**RESPONSE TO SUBMISSIONS (RtS) SSD-10468
WAREHOUSE AND CUSTOMER FULFILMENT CENTRE
74 EDINBURGH ROAD, MARRICKVILLE**

Thank you for requesting Transport for NSW (TfNSW) to review a supplementary Response to Submissions (RtS) and amendment report for SSD-10468 'Woolworths Warehouse and Customer Fulfilment Centre' at 74 Edinburgh Road, Marrickville.

**Figure 2** Concept design for the Edinburgh Road / Smidmore Street signalised intersection upgrade works

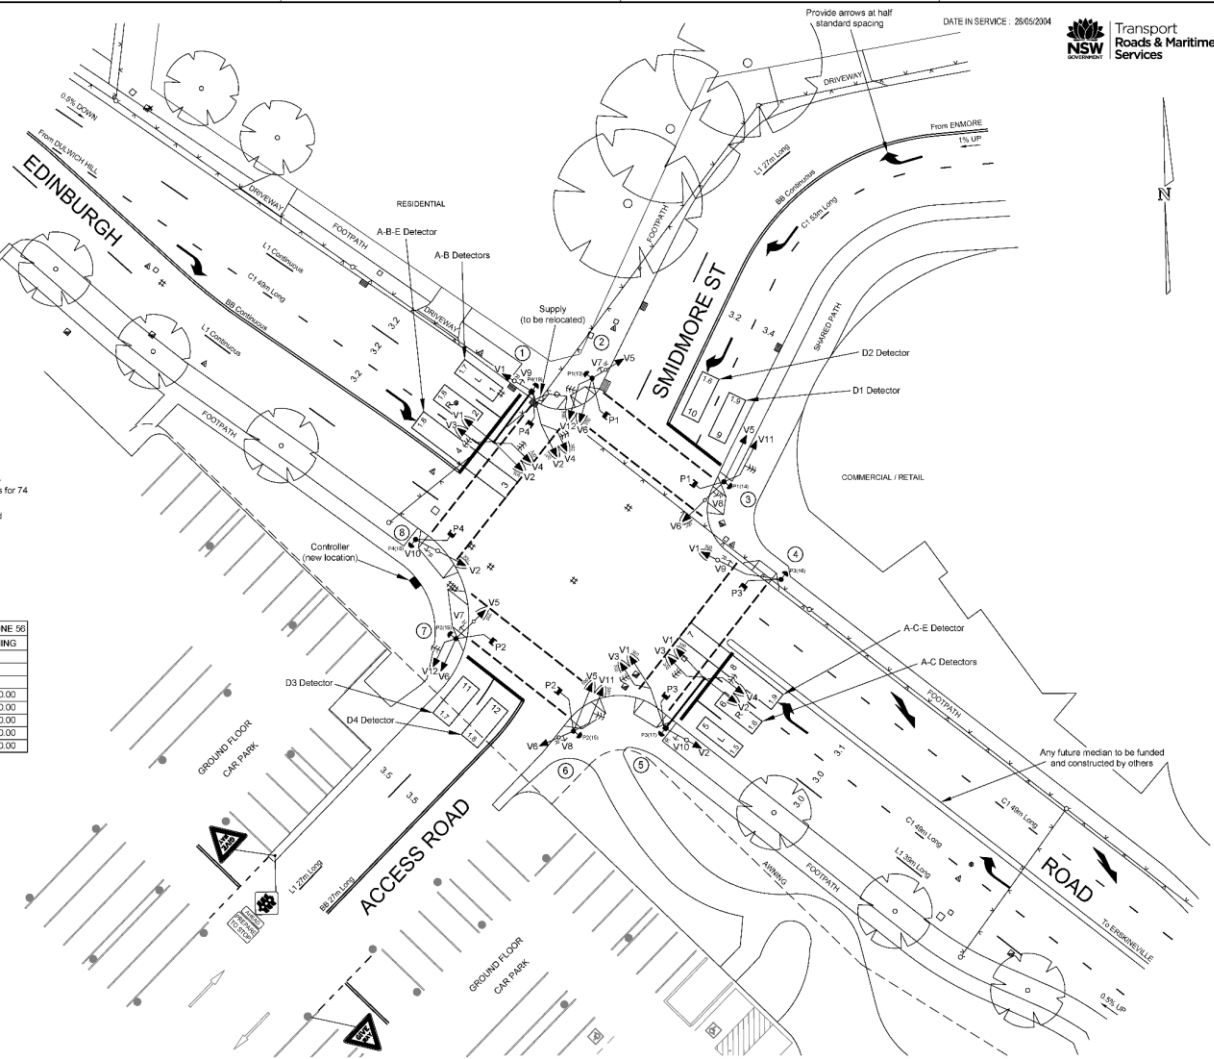
TfNSW has reviewed the amended Traffic Assessment and consolidated traffic response regarding the proposed changes to the existing signalised intersection of Edinburgh Road / Smidmore Street traffic control signals (TCS). TfNSW is satisfied with the submitted information and provides 'in-principle' support with the concept TCS plan to support the proposed development.

As Edinburgh Road / Smidmore Street signalised intersection has been identified to be upgraded to ameliorate the traffic generated by the development, TfNSW recommends that this is completed prior to issuing of a completion certificate and provides the below

TfNSW recommends that Edinburgh Road / Smidmore Street signalised intersection is upgraded prior to the issuing of the completion certificate and the following as a suggested condition of consent:

- The developer shall upgrade the Edinburgh Road / Smidmore Street signalised intersection per TfNSW requirements.

The developer will need to obtain section 87 of the *Roads Act 1993* approval for the associated works from TfNSW, which shall be done prior to the issuing of the completion certificate.
